From: Maria Tomalova
Sent: 16 August 2019 16:03
To: Planning Scanning
Subject: FW: BR/154/19/PL, 8 Mead Court

One of the grounds was a lack of parking spaces provided.
I have been on the site and the site is big enough to accommodate 4 cars,
What is a requirement for 8- bed HMO.

SITE PLAN - 1/500

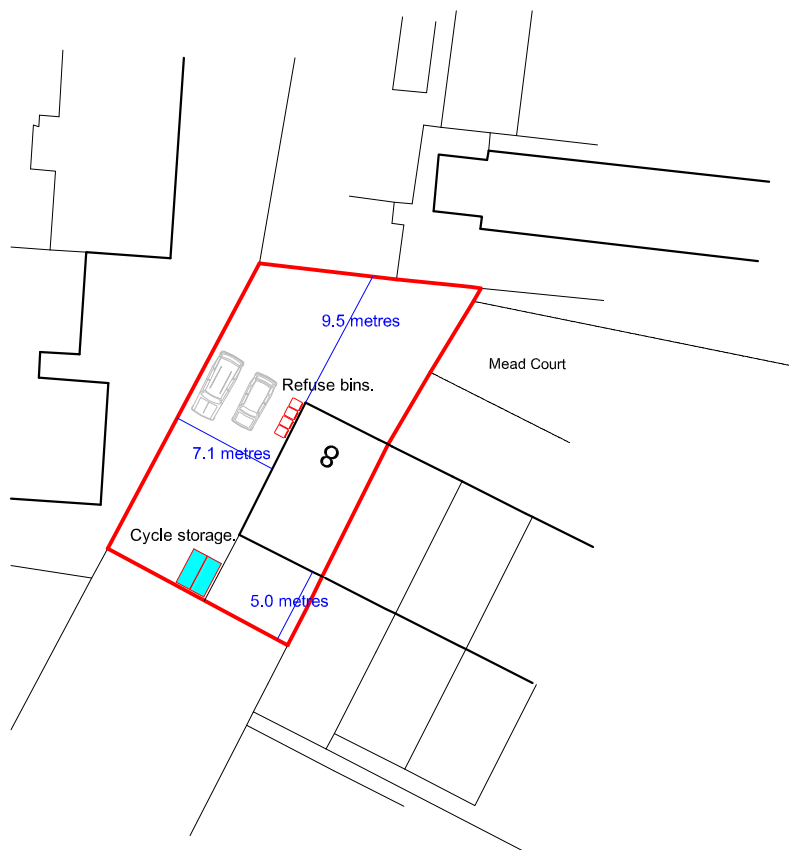
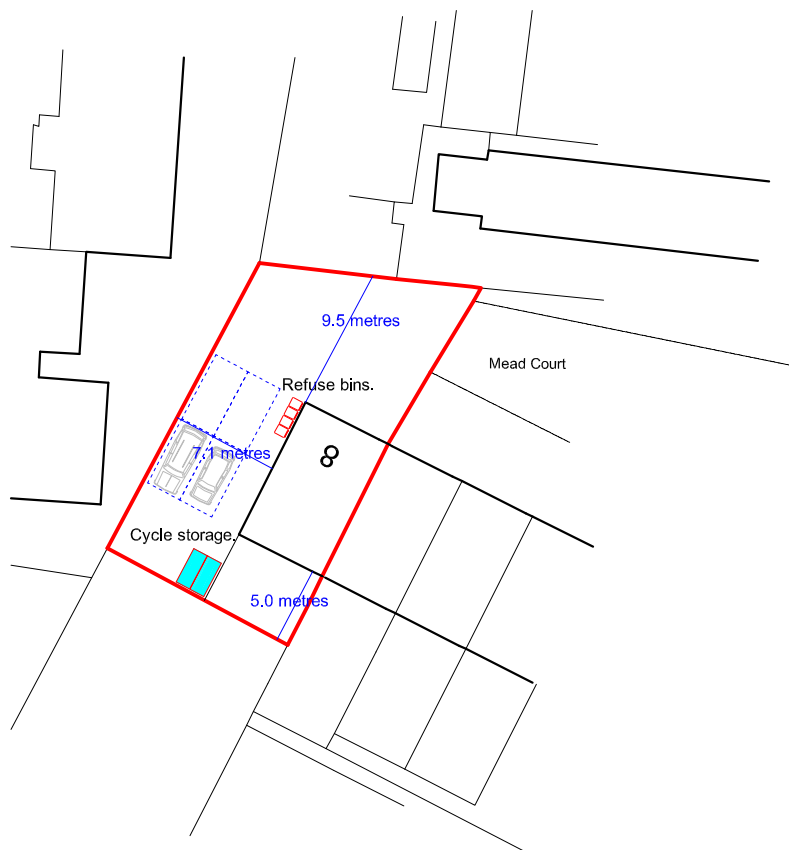
It would be helpful if you can demonstrate the provision of 4 parking spaces.

The site as you will know is more than capable of taking twice the amount, however, I attach a copy of a revised site plan indicating 4 x spaces as requested – I trust that this is ok?
